# Charlotte Department of Transportation

## Memorandum

**Subject:** Rezoning Petition 08-152: Located on the southwest corner of Beatties Ford Road and Fairdale Drive

04DEC08	NEW SURVEY
17NOV08	ZONING COMMENTS
PROJECT	0812
DATE	21APR08
DRAWN BY	PML
CHECKED BY	CEL
SITE PLAN	
A1

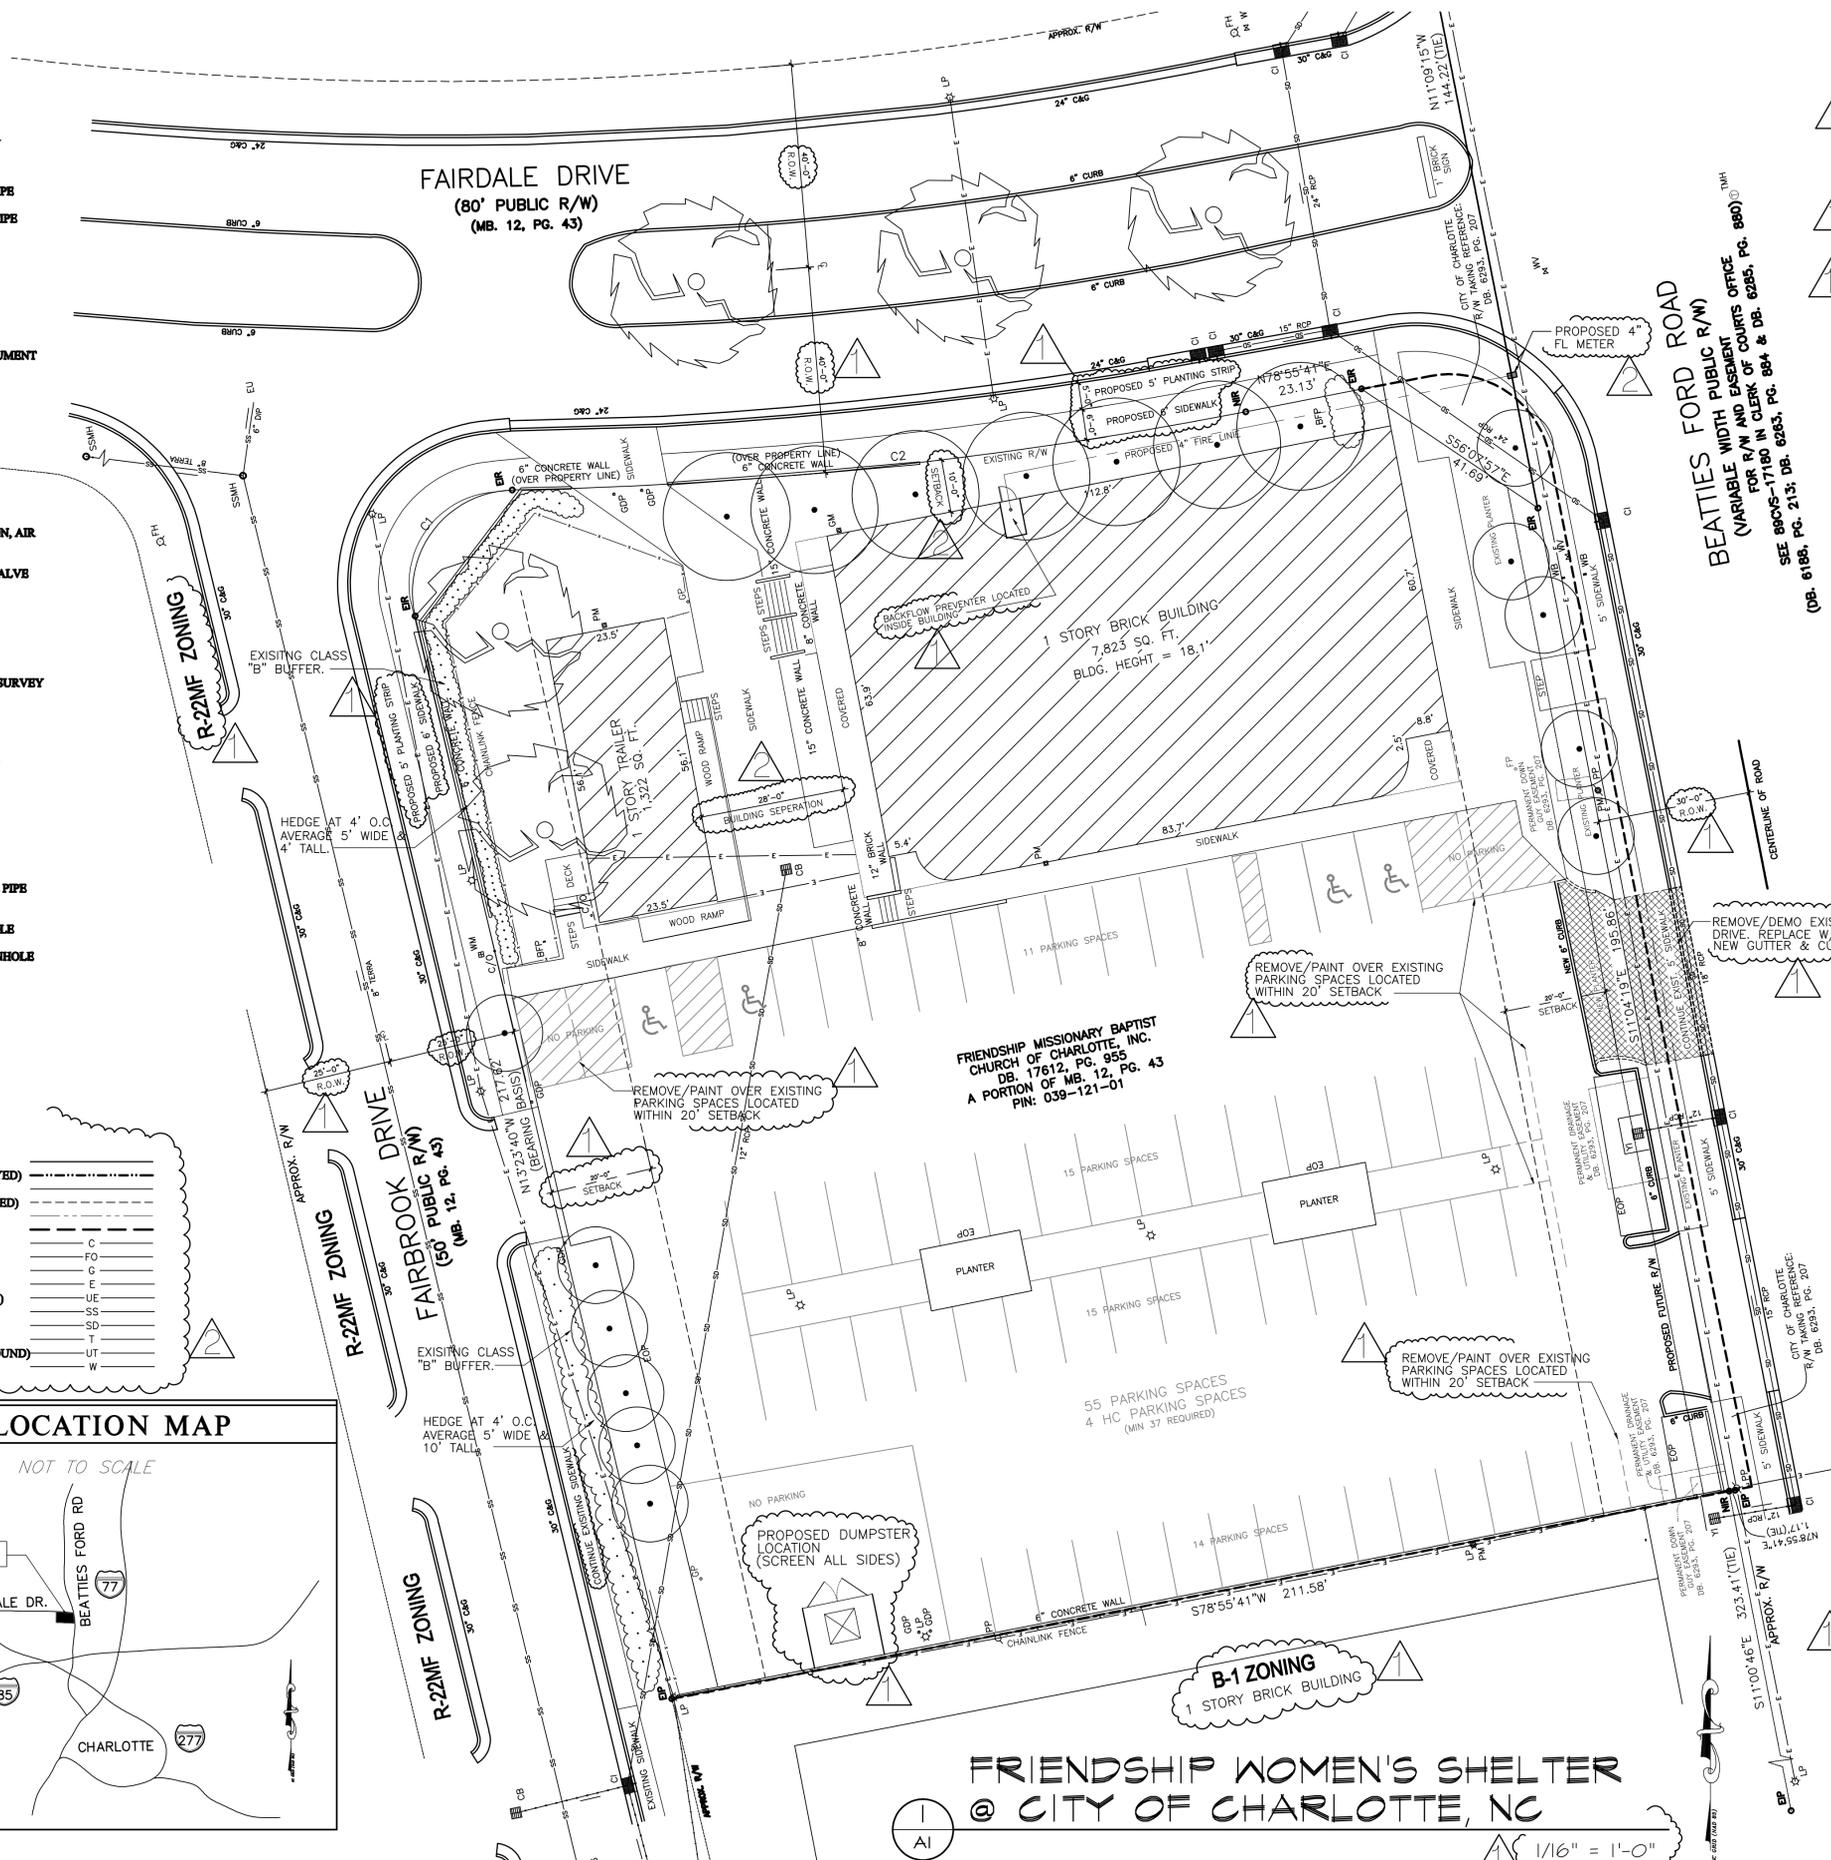
1. Parking spaces and drive aisles are not permitted in the setback. As shown on the site plan, parking spaces and drive aisles located in the setback need to be removed and the site plan revised accordingly.
2. The bus storage area conflicts with the drive aisle for the adjacent parking area and is located within the setback. The site plan needs to be revised to eliminate these conflicts and to provide a minimum drive-aisle width that allows for adequate access to parking spaces/2-way operation without obstruction.
3. The developer needs to replace the existing sidewalks at the back-of-curb along Beatties Ford Road with 12-foot planting strips and 6-foot sidewalks.

SITE PLAN

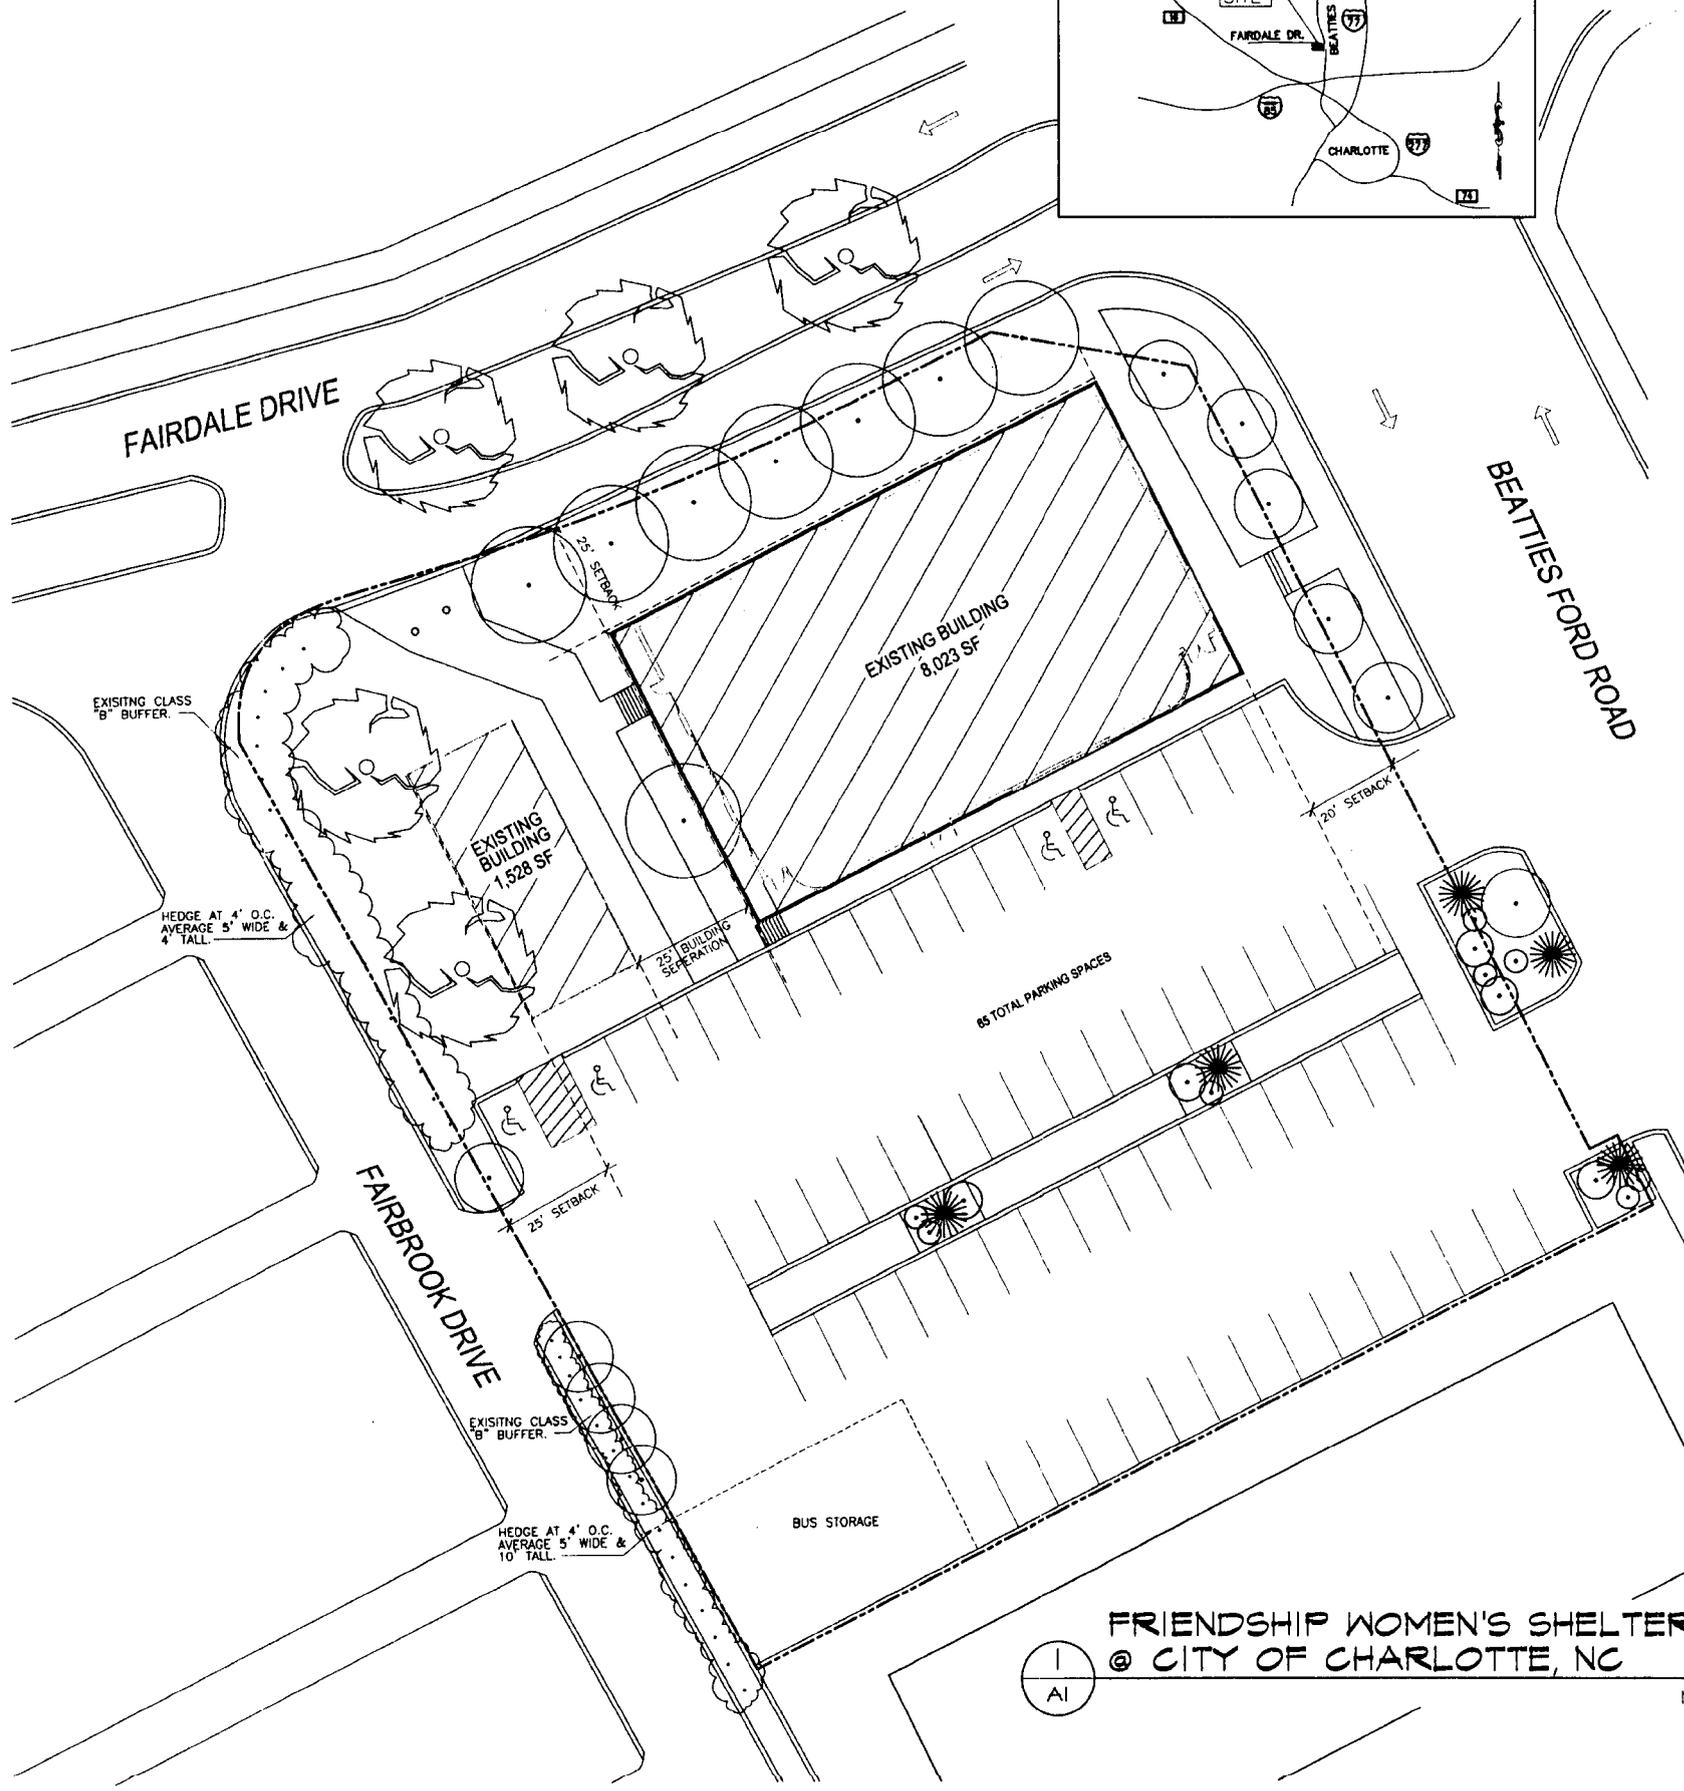
4. The developer needs to construct 8-foot planting strips and 5-foot sidewalks along Fairdale Drive and Fairbrook Drive.
5. The site can be adequately served by one driveway on both Beatties Ford Road and Fairdale Drive. The driveway on Beatties Ford Road closest to its intersection with Fairdale Drive needs to be removed and replaced with curb, gutter, and sidewalk.
6. It is not clear in the site plan how the waste collection will be handled for this site. If the petitioner proposes to use a dumpster, the location needs to be shown on the plan as well as the maneuvering path of the waste collection vehicle. The maneuvering path cannot conflict with parking spaces or be located in the setback.
